**Re: Objection to Planning Application 2024/70/92167/W for Development at Land off Edgerton Road, Edgerton, Huddersfield, HD3 3AA.**

I am writing to formally object to the planning application for the proposed development at Clayton Fields. As a resident whose property borders the rear boundary of the development site, I have significant concerns regarding the adverse effects this proposal will have on both my property and the wider local area. My objections are as follows:

Deveron Grove
Proposed Site Layout

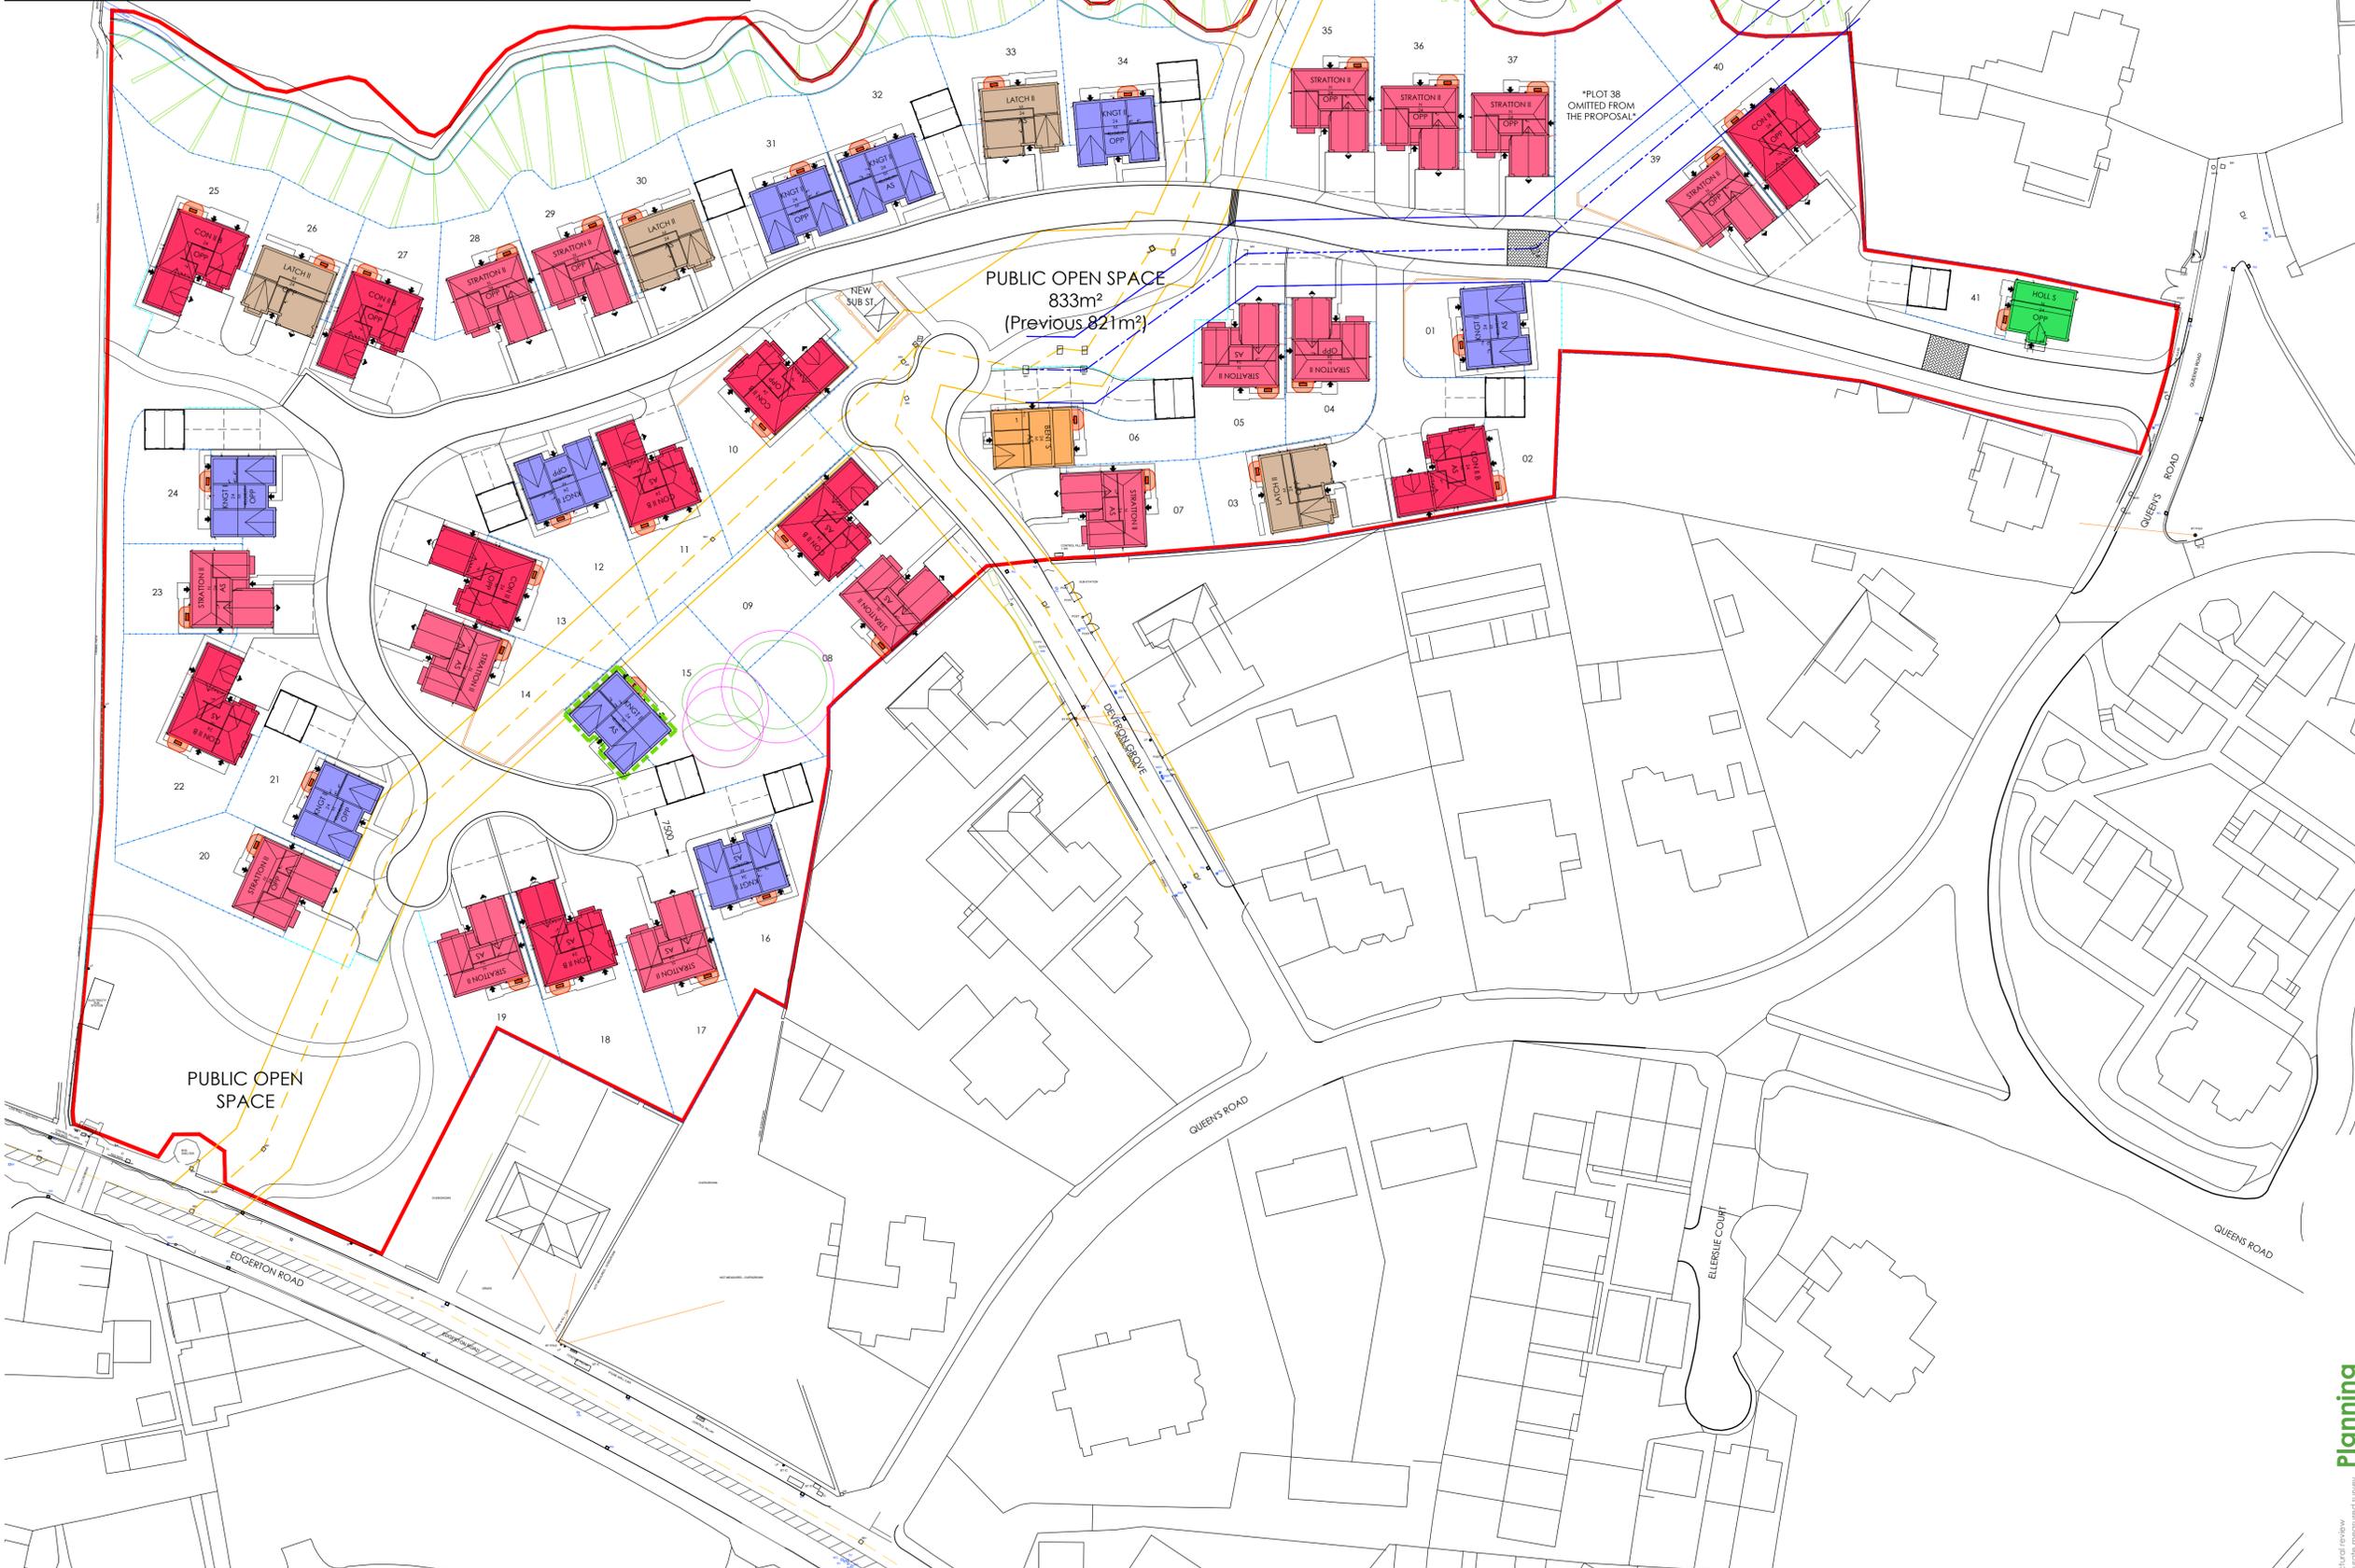
**1. Proximity of Plot 16 to the Boundary**

The proposed house on plot 16 is planned to be built extremely close to my property's boundary, where there is a steep slope that drops down 3 to 4 feet, retained by an old dry-stone wall which is 5 feet tall, resulting in an 8 to 9 foot difference in height between the ground level of plot 16 and my own garden. This wall has already been compromised by the roots of a large oak tree near the boundary. I am concerned that constructing a property so close to this wall will exacerbate existing damage and lead to further structural issues. The wall's integrity is already fragile, and additional pressure from the new development poses a serious risk.

**2. Impact of Ground Level Differences and Privacy Concerns**

Due to the sloping nature of the development site, there is a significant difference in ground levels between plot 16 and the rear of my garden. As a result, the proposed building will effectively be a three-storey property just a couple of metres from my boundary. This will loom over the neighbouring properties, particularly number 9 Deveron Grove, which sits at an even lower level than my own garden. The ground floor of the property on plot 16 will have a direct line of sight into the bedroom and ground floor windows of number 9 Deveron Grove, severely compromising the privacy of its occupants. This represents an inappropriate development that negatively affects the surrounding properties.
